CATHEDRAL PINES SUBDIVISION FILING NO. 2, LOT 51
AN AMENDMENT TO LOT 51, CATHEDRAL PINES SUBDIVISION FILING NO 2

June 1, 2018

Subject: VR-18-005 Re – submittal letter

# CATHEDRAL PINES SUBDIVISION FILING NO.2, LOT 51

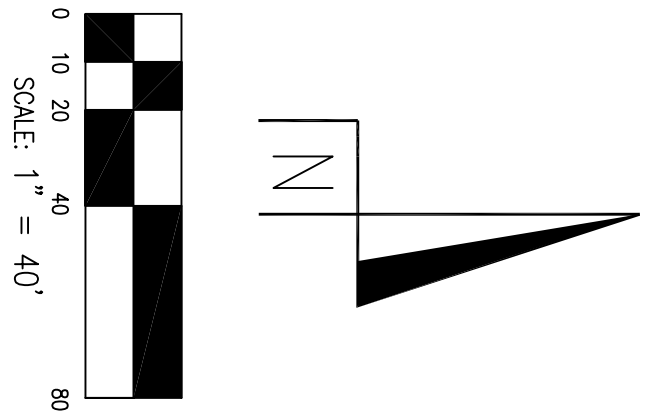
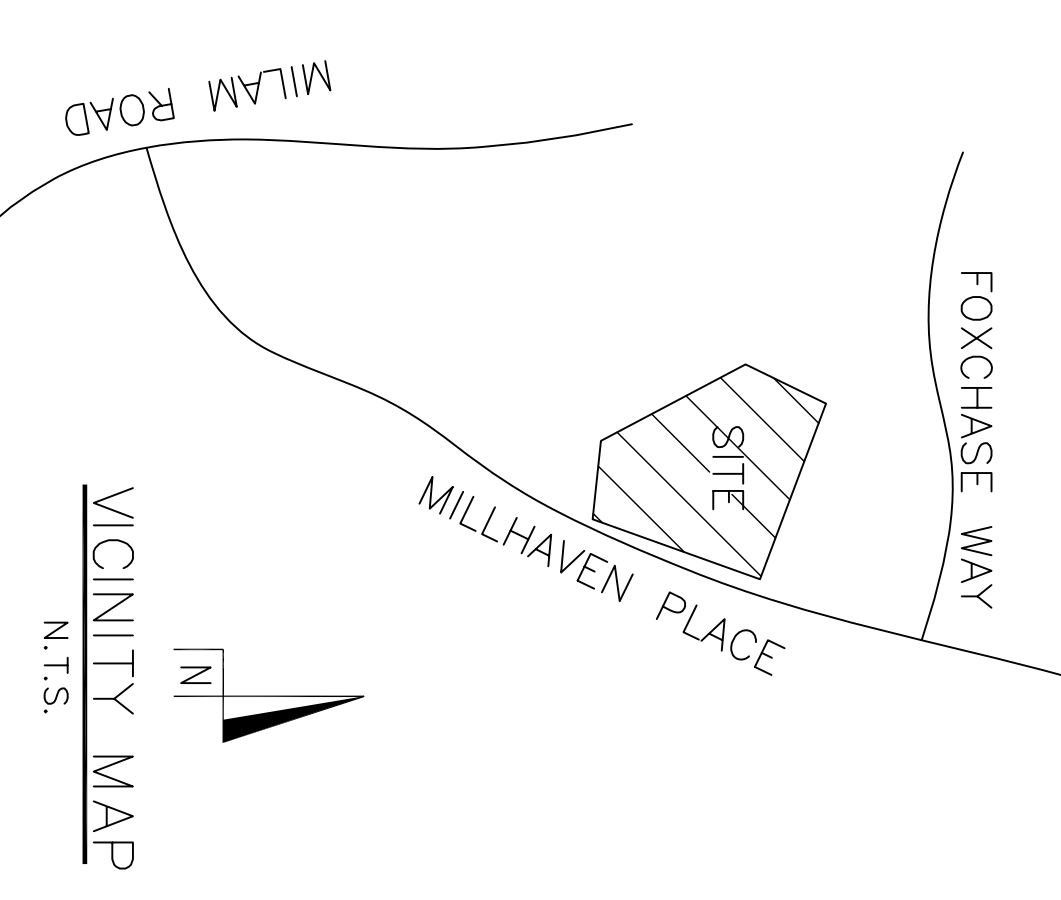
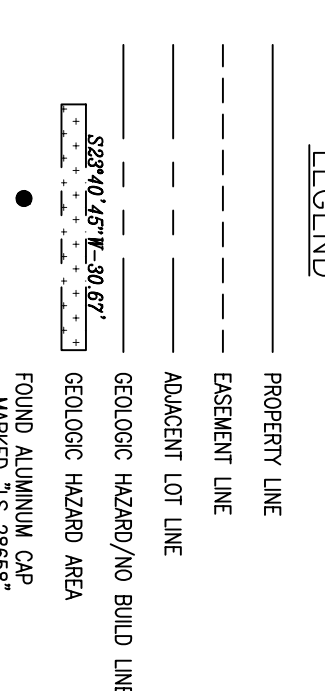
10. This note is for the entire Development and not the individual Lot owners responsibility. These have already been completed by the

Developer. Refer to note 14 (new note 19.) Not added - lot still a part of the SIA agreement, note required

11. This note is for the entire Development and not the individual Lot owners responsibility. The Lot owner is responsible for their own well only. Refer to note 14 (new note 19.) Not added - this note clearly states any owner or successor has the responsibility to notify the HOA and future owners, note required

12. This note is for the entire Development and not the individual Lot owners responsibility. The Lot owner is responsible for their own well only. Refer to note 14 (new note 19.) Not added - The augmentation plan is still required to be noted on this plat, as the well is still a part of that augmentation plan, note required

15. The PUD plan, Millam Road improvements are not the responsibility of the Lot owner. Refer to note 14 (new note 19.) Not added - This lot is still subject to the PUD Development plan, note required

18. This note pertains to the lots listed, this lot has already submitted this information for review and approval requiring this Amended Plat for this lot only. Refer to note 14 (new note 19.) Not added - note required for any future development on lot, note required

23. This is the Developers responsibility and not the individual Lot owner. These requirements have already been adhered to by the Developer or the sale of these individual lots would not be possible. Refer to note 14 (new note 19.) Not added - This advises all future owners of the requirements, note required

The original Note 14 (new note #19) should remain as was requested from

previously submitted Amended Plats in this area. - Having this note means that all future property owners, county staff, building department would have to reflect on two separate plats to make sure all standards are meant. It is the responsibility of the applicant at time of vacate replat to apply these notes or an approval may not be able to be done, any previously approved amendments does not warrant an approval of this application.

ALLIANCE BUILDERS: Pinnacle Land Surveying corrected – Note added to final plat.

ALLIANCE BUILDERS: Pinnacle Land Surveying corrected – Note added to final plat.

ALLIANCE BUILDERS: Pinnacle Land Surveying corrected – Note added to final plat

ALLIANCE BUILDERS: Pinnacle Land Surveying corrected – Note added to final plat

ALLIANCE BUILDERS: Pinnacle Land Surveying corrected – Note added to final plat

ALLIANCE BUILDERS: Pinnacle Land Surveying corrected – Note added to final plat

ALLIANCE BUILDERS: Pinnacle Land Surveying corrected – Note added to final plat
